Application No: EP/60/21/HH
Site Address: New Lodge Seaview Road East Preston BN16 1LX
Description of works: Erection of two side dormers

This council's Planning & Licensing Committee considered this Application at its meetings on Monday 28th June and 12th July. The applicant was invited to both meetings and attended the first, sending apologies for the second.

CLIENT: Mr & Mrs Gibb
DATE: 19.03.2021
DRWG No: BSB/21/836/2

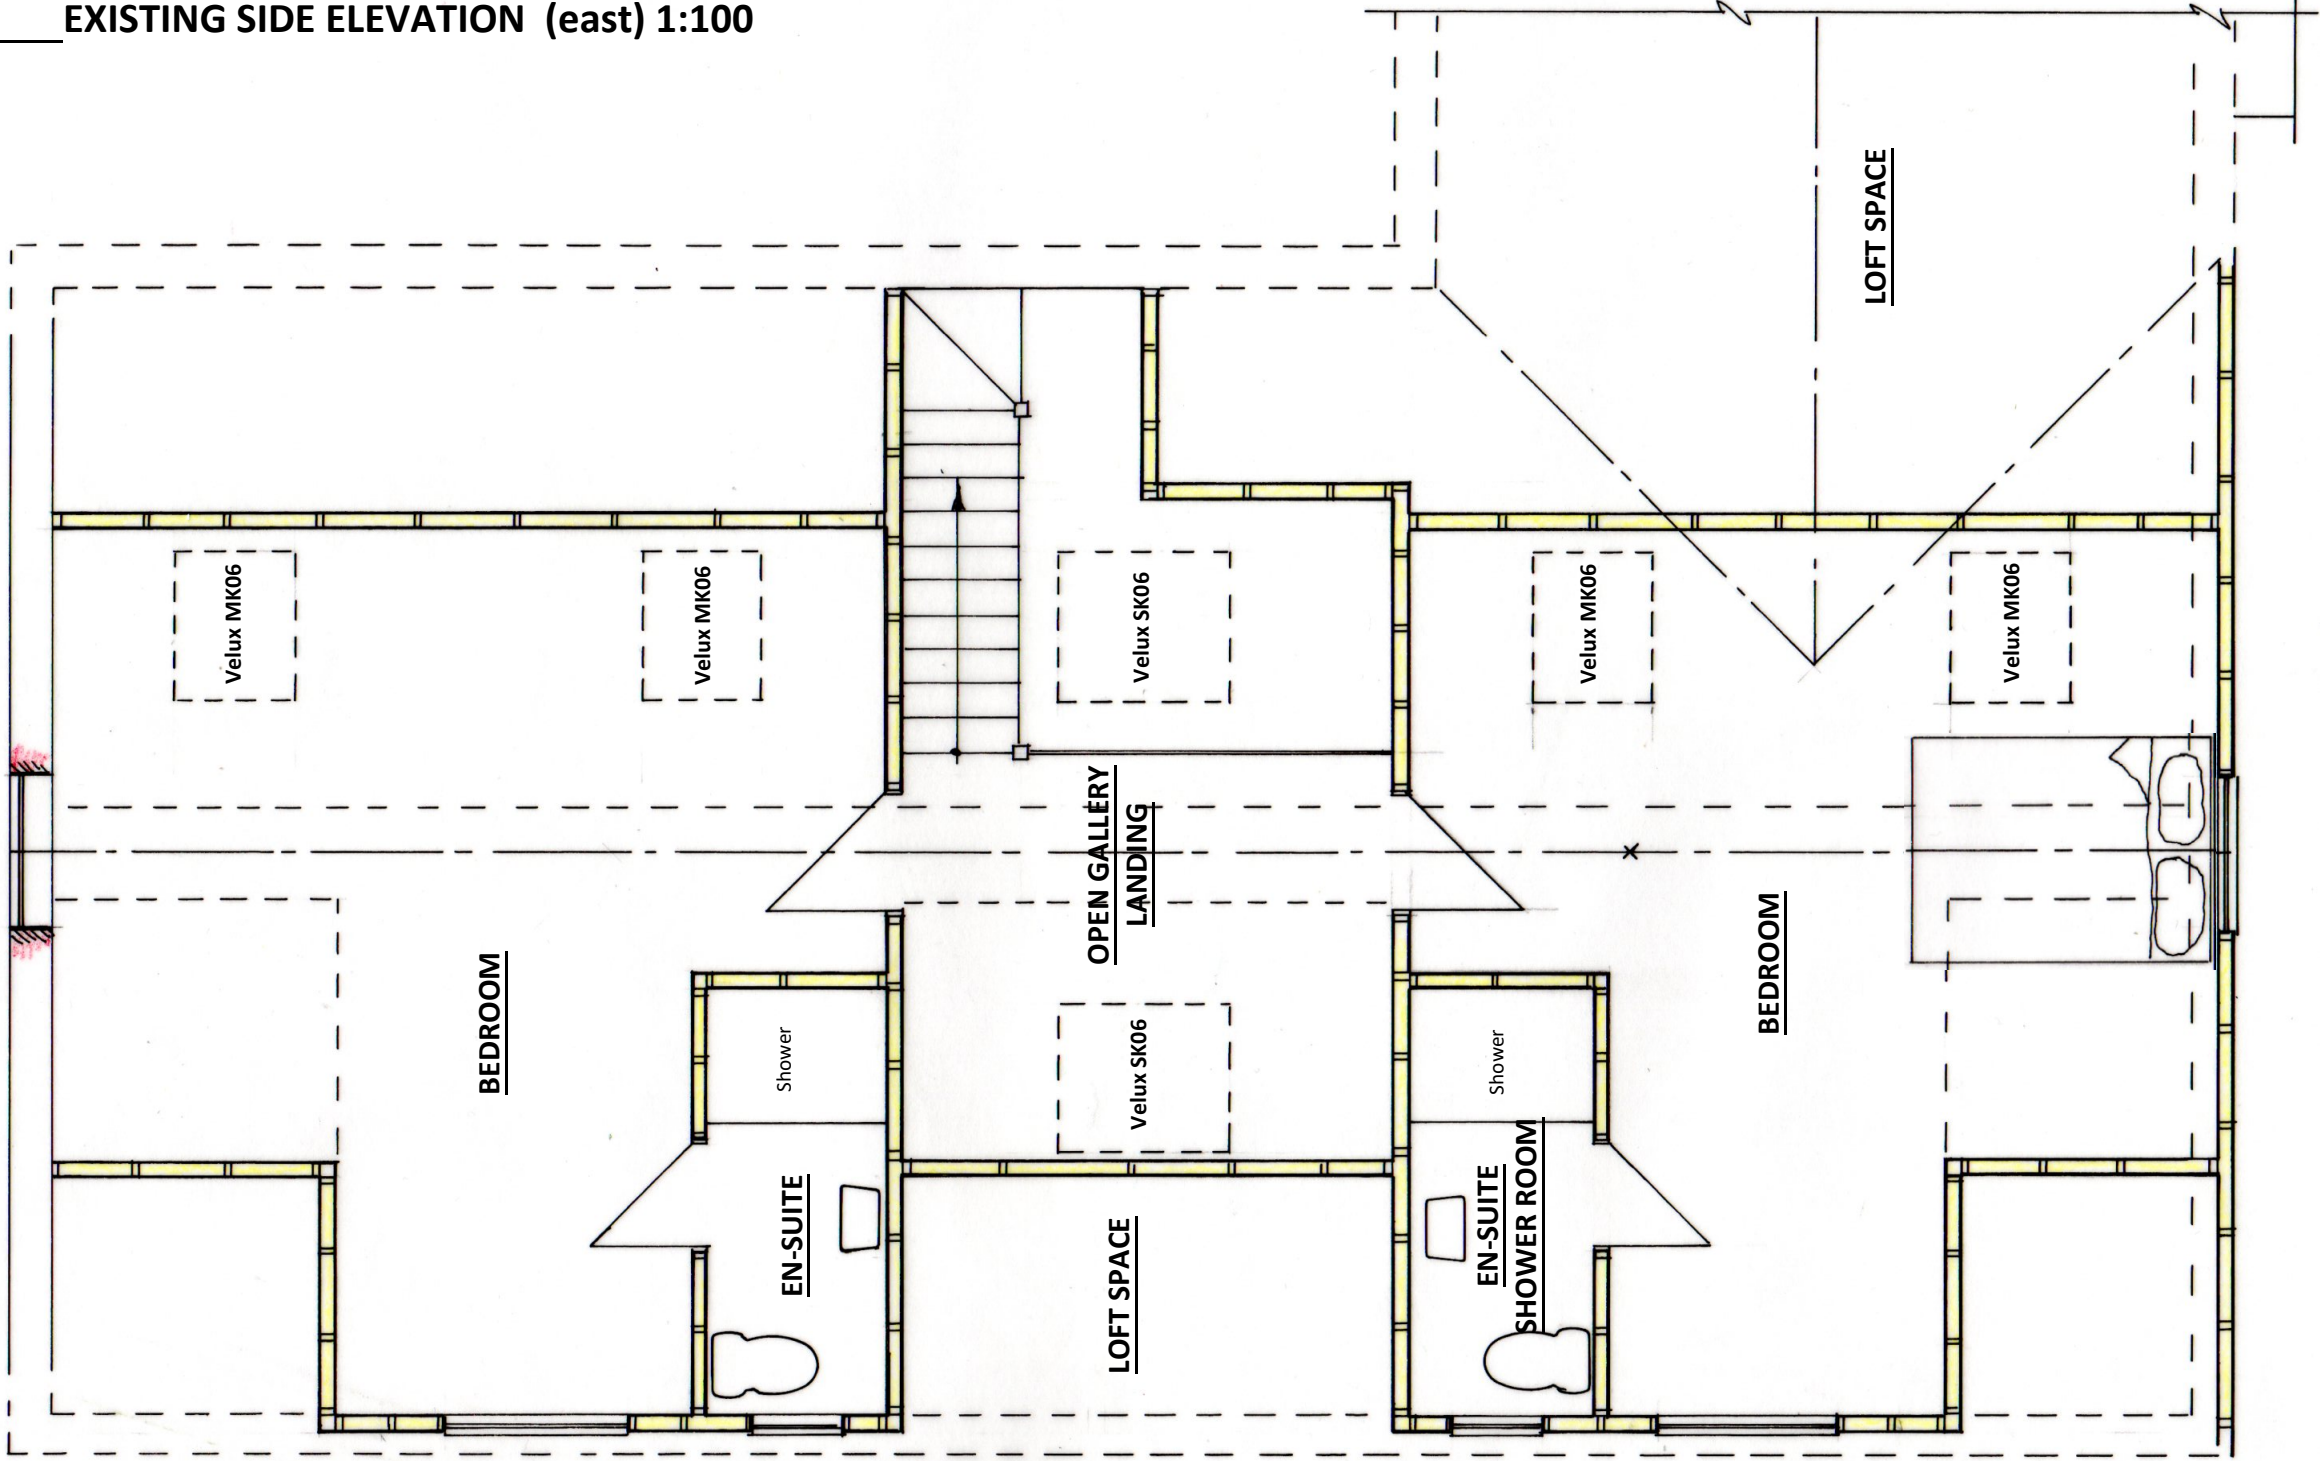
On drawing BSB/21/836/2, an existing side elevation shows a dormer already in place. These dormers are not existing. There is no indication of North on this drawing and it would appear South is unorthodoxly at the top of this drawing.

PROPOSED SIDE ELEVATION 1:100

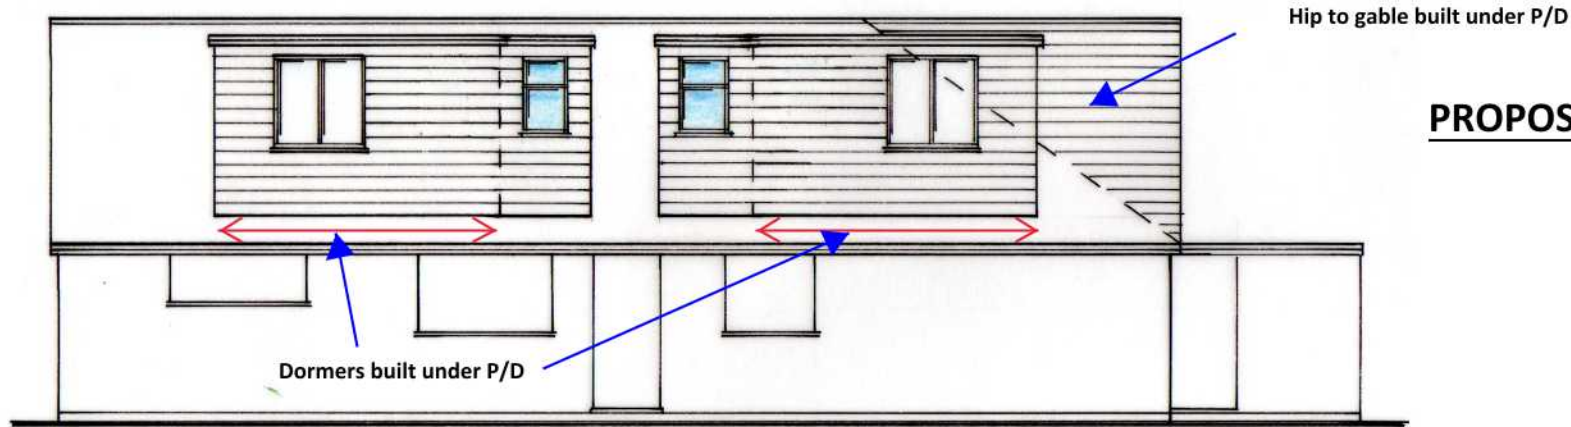
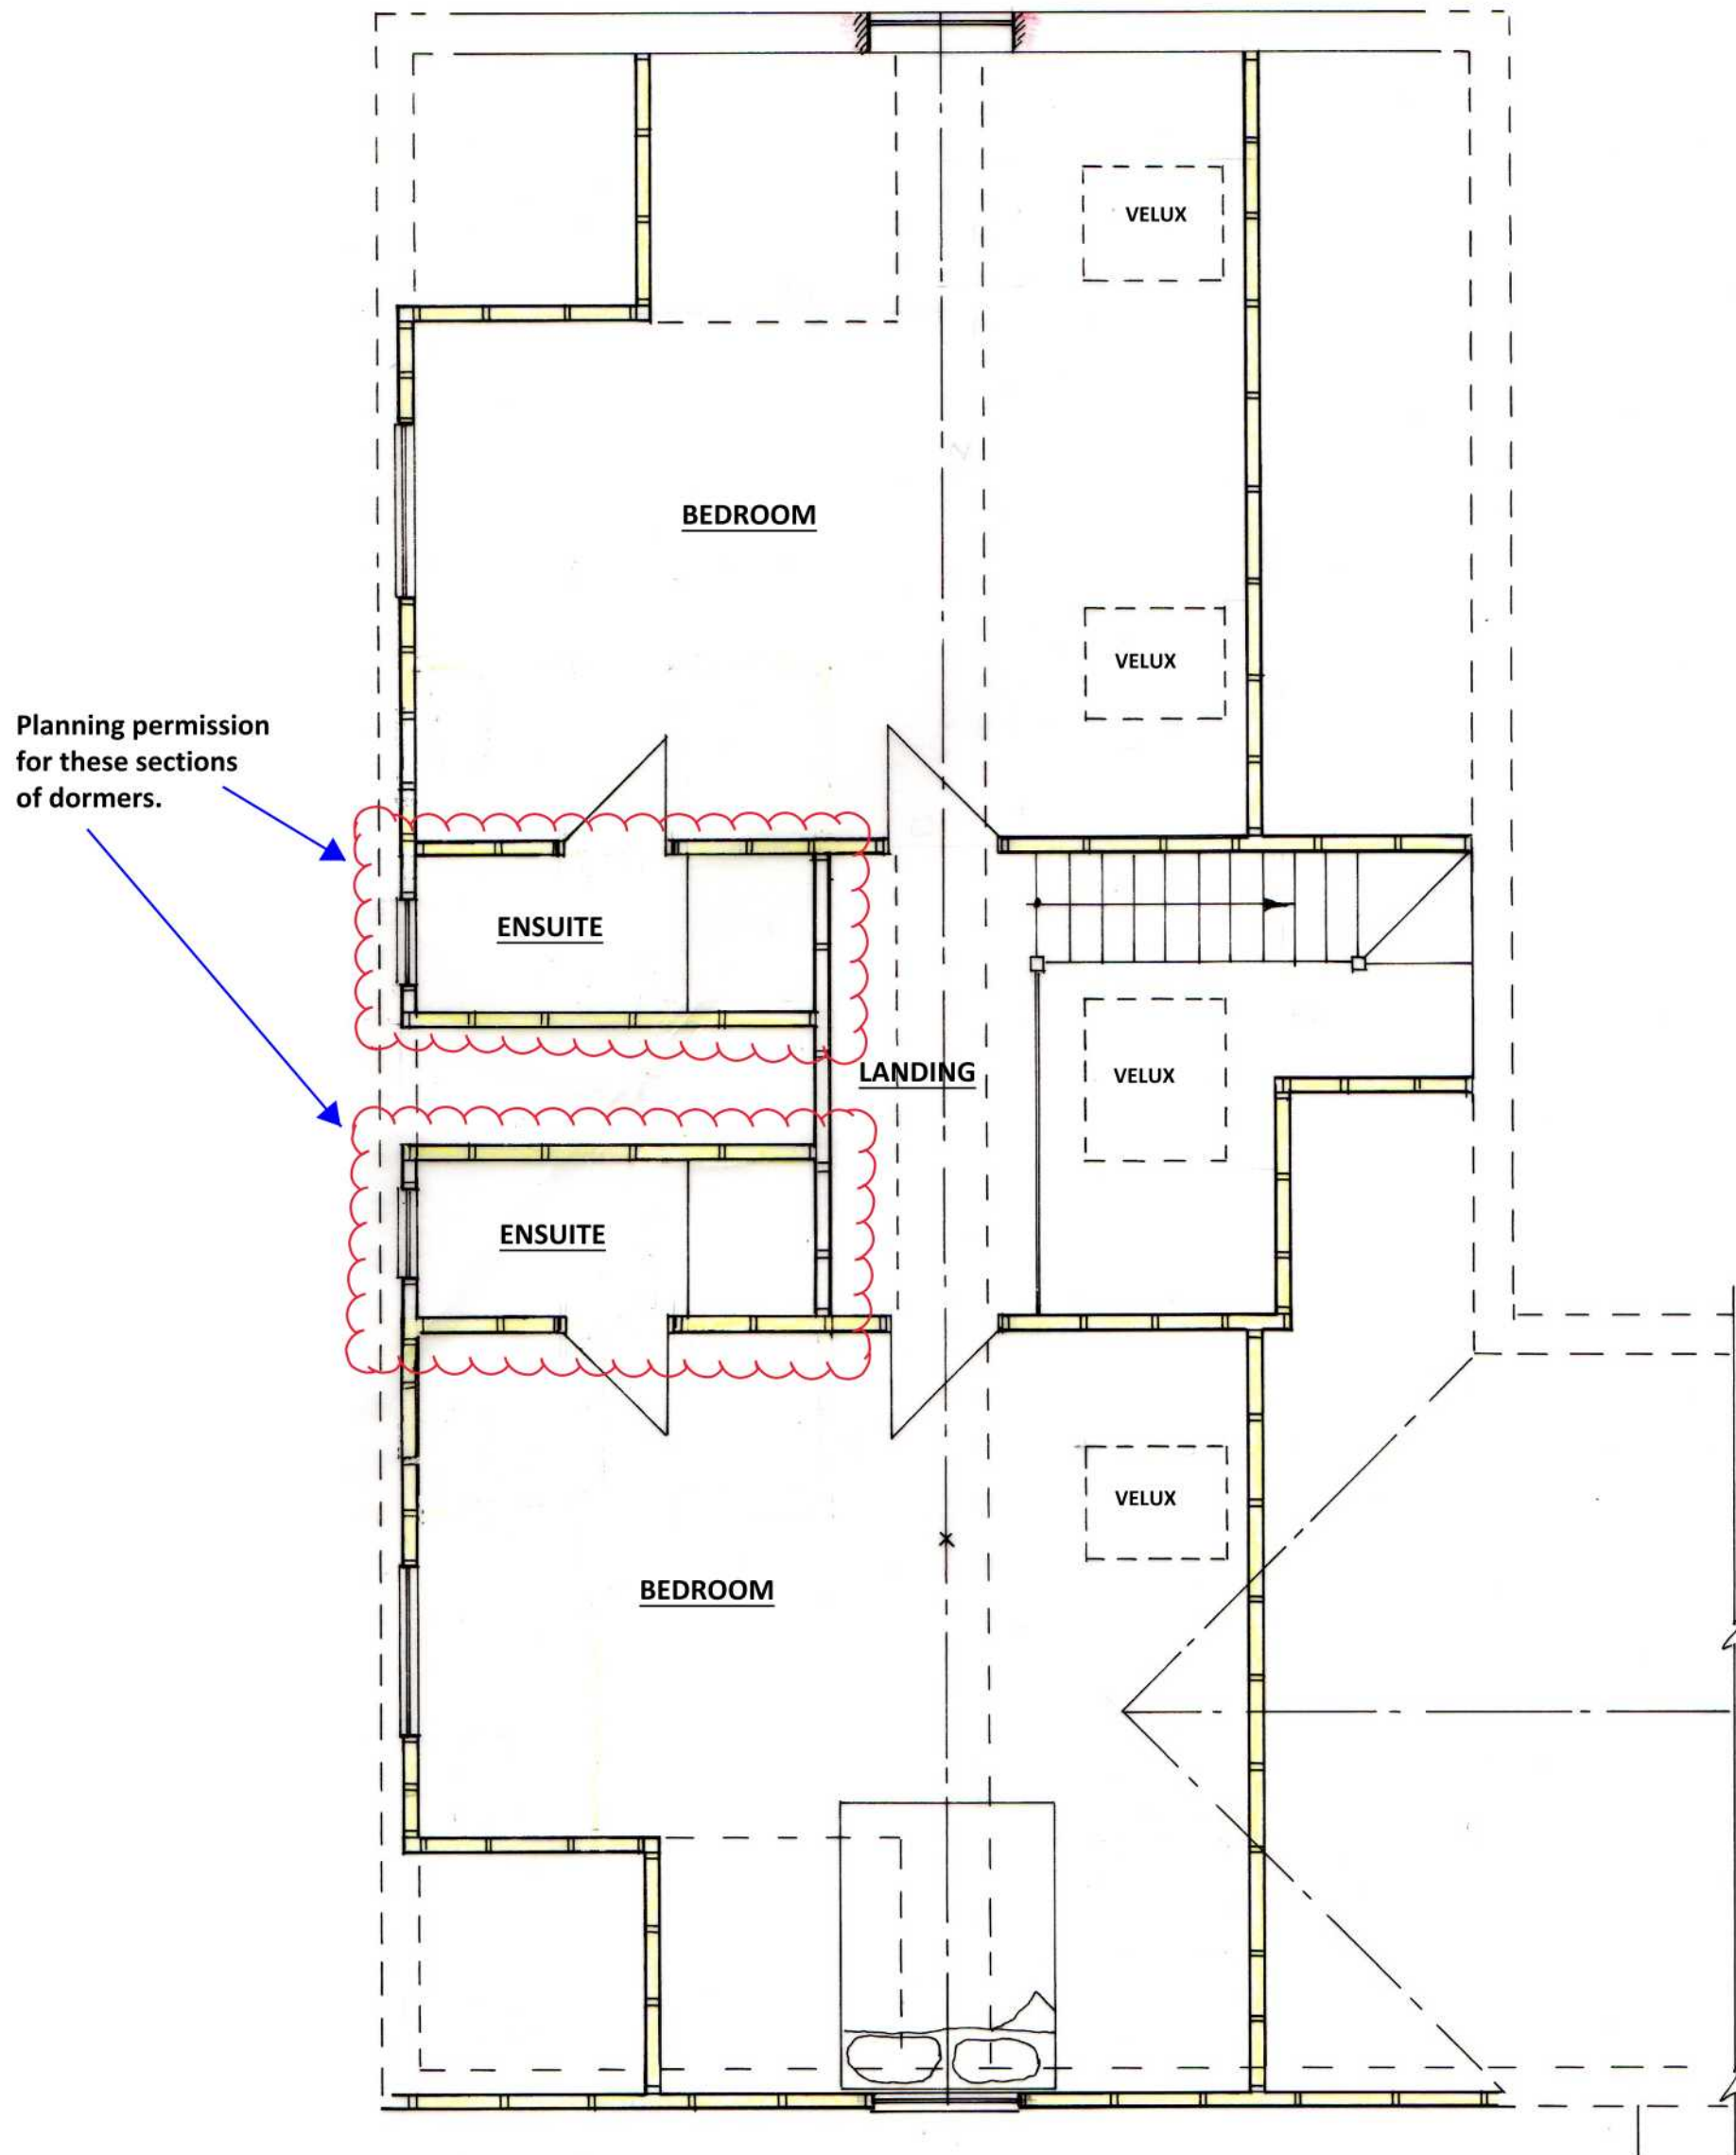
Drawing BSB/21/836/3 also has no indication of North, and again South would appear to be at the top of the page.
